# A R C H I T E C T Y P E

May 22, 2015

RE: The Science Center  
68 Maine Wharf  
Portland, Maine

Date: 5-13-2015
Scale: AS NOTED
**NEW COMMUNICATING
STAIR DETAILS**

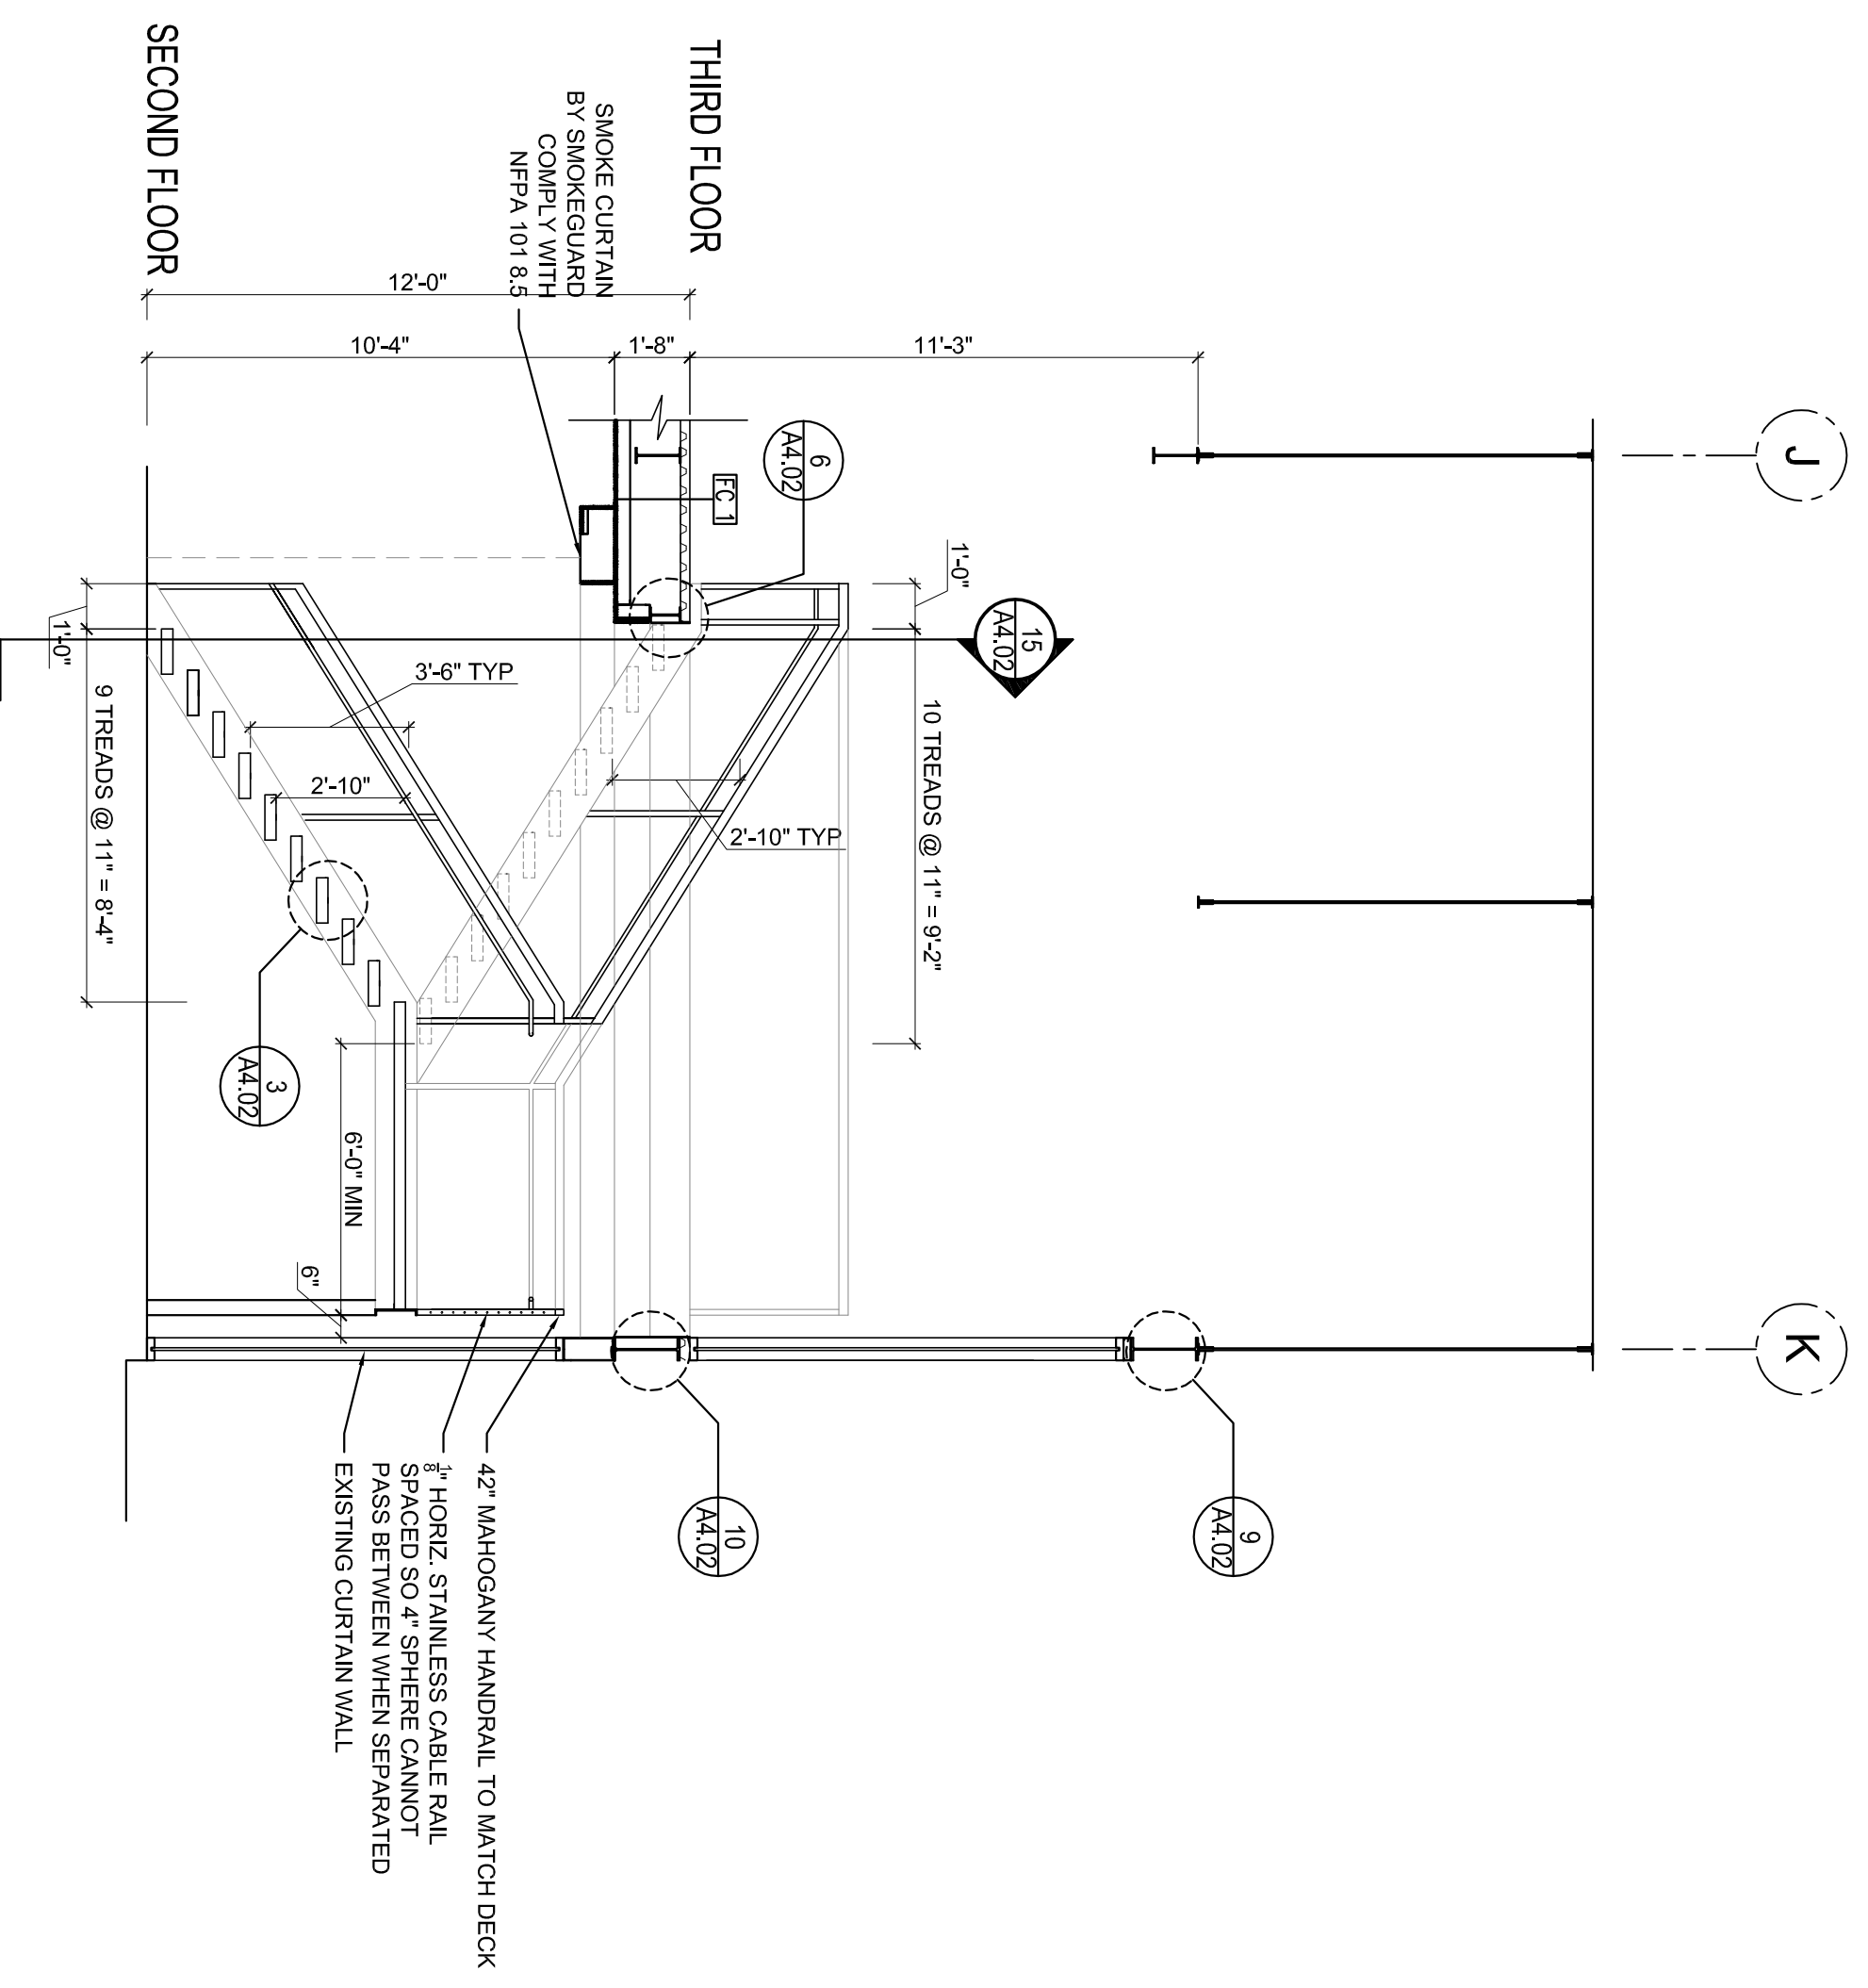
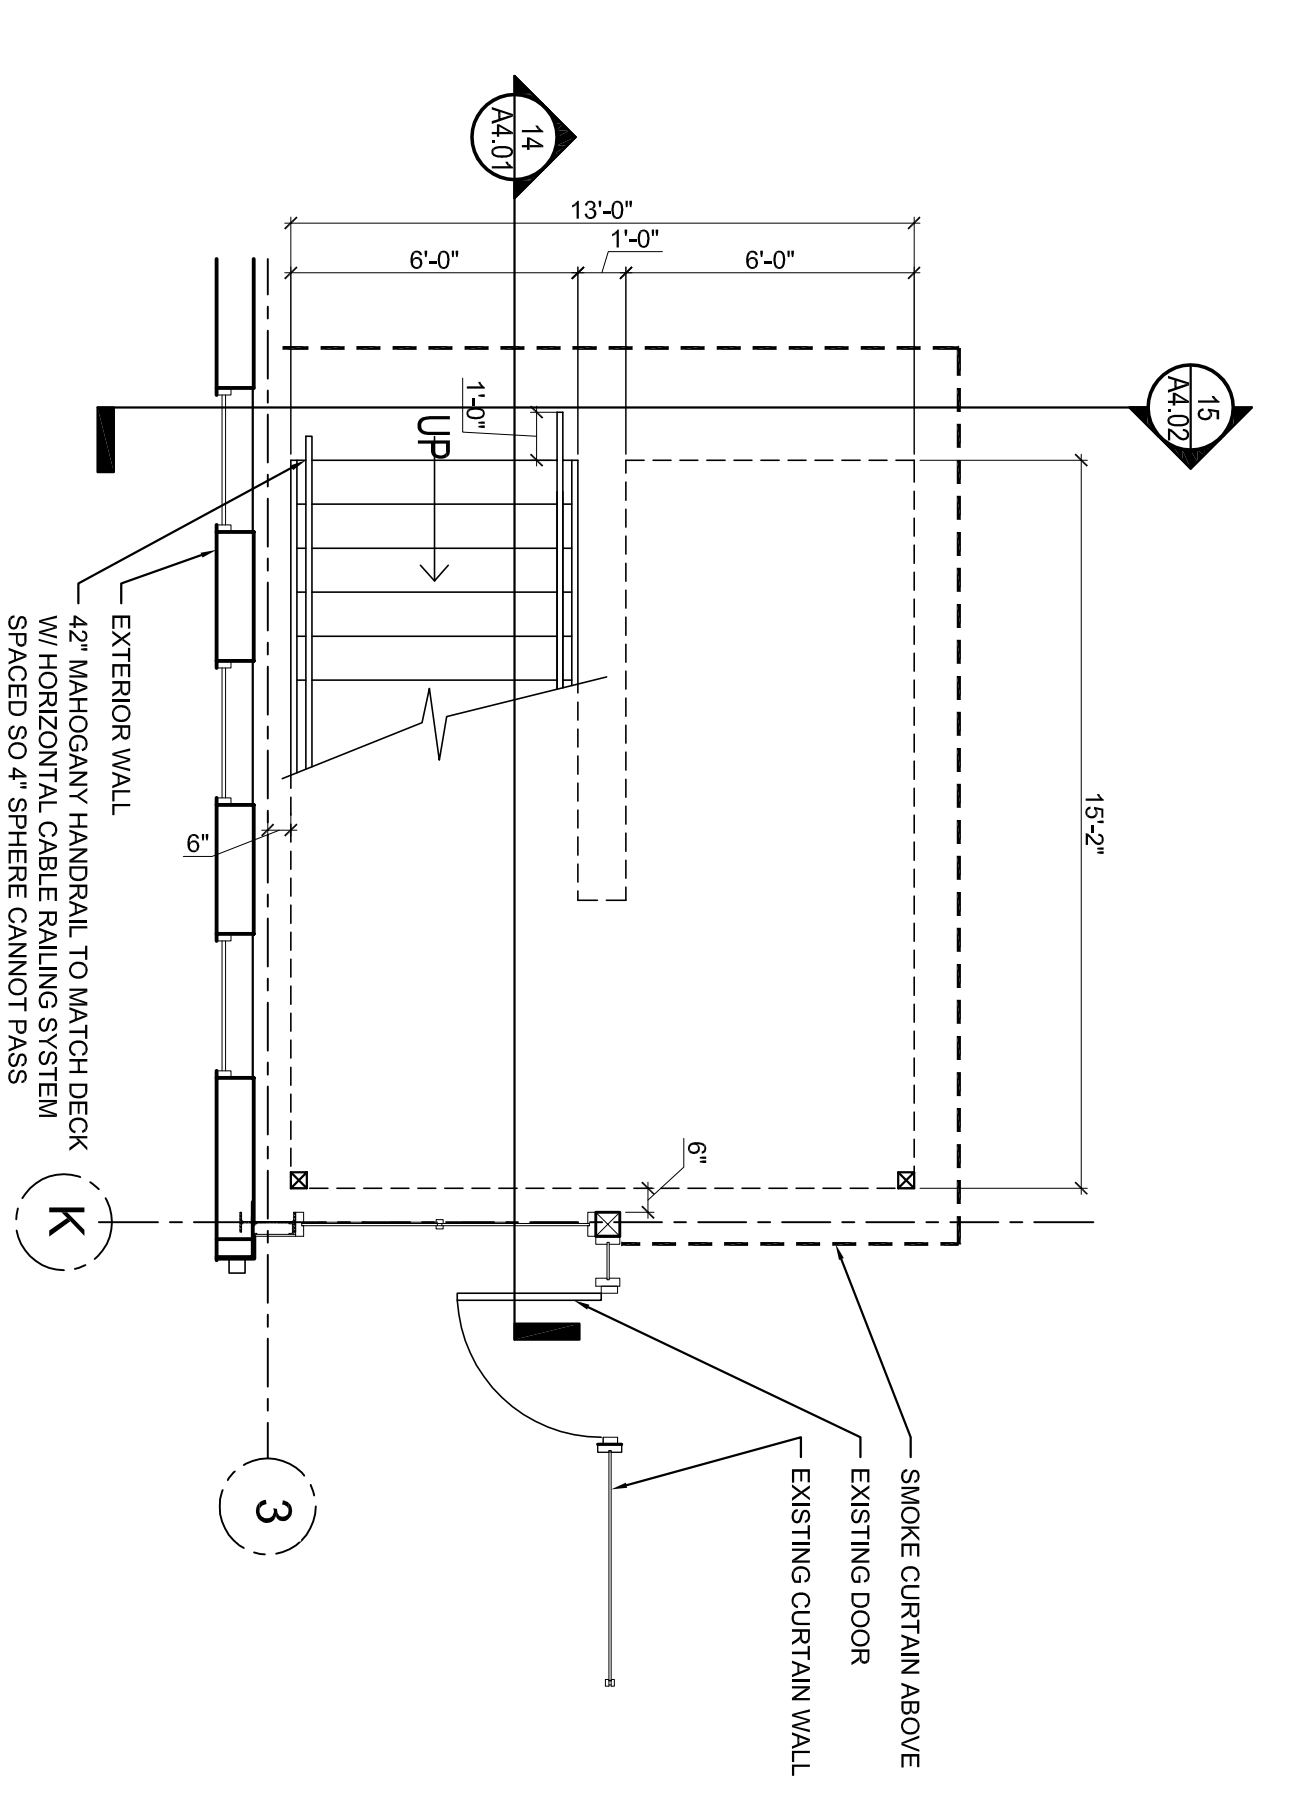
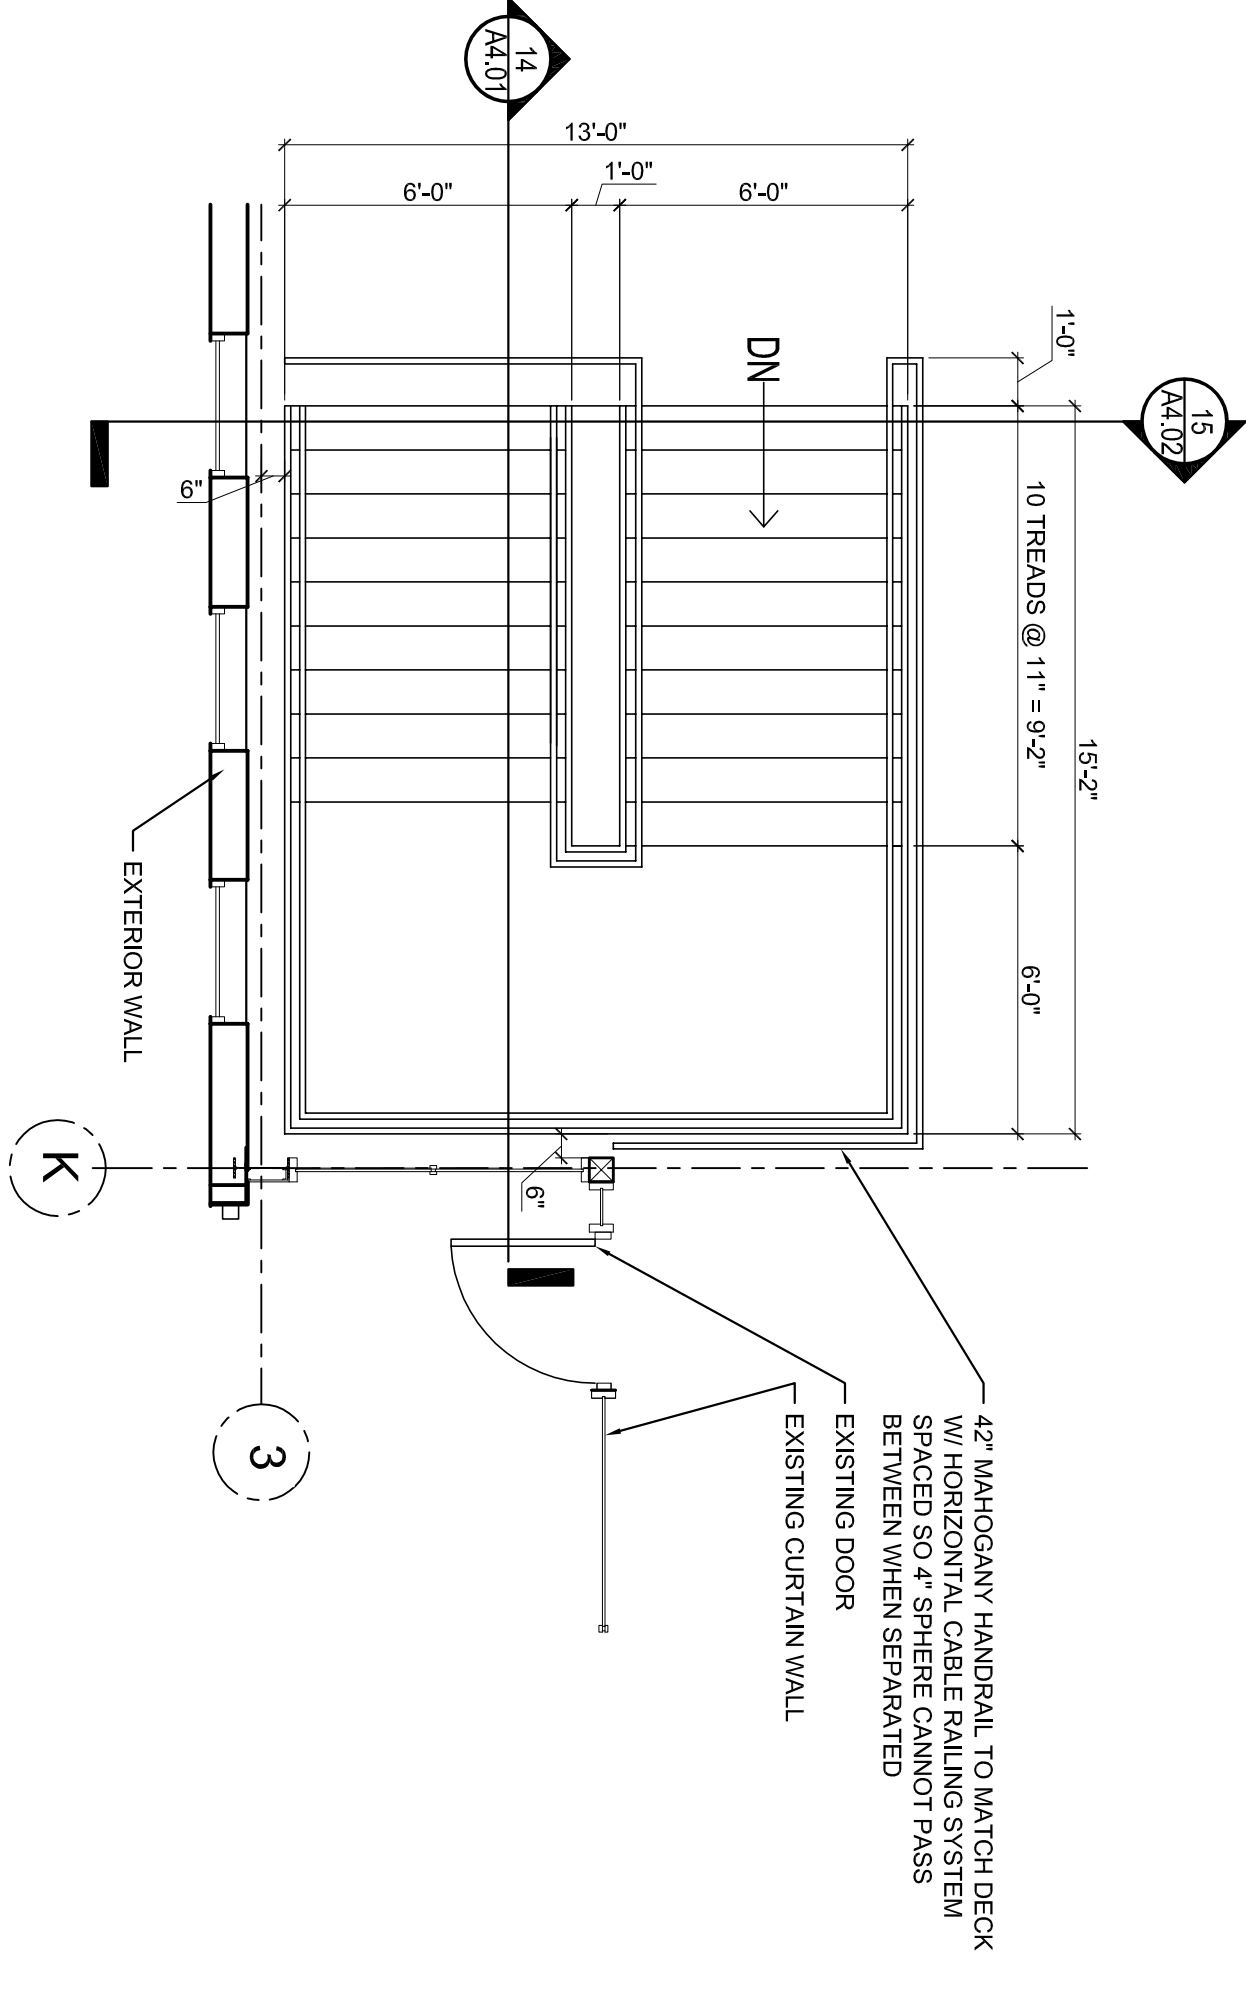
In the course of our own internal review of the project Mark Cummings of Fire Risk Management noticed that the common path of travel from the south end (or right side of the floor plan) to the nearest exit stair exceeds the allowable distance for an assembly occupancy. I have attached Marks suggestion to incorporate our proposed convenience stair into our egress along with our revised drawings.
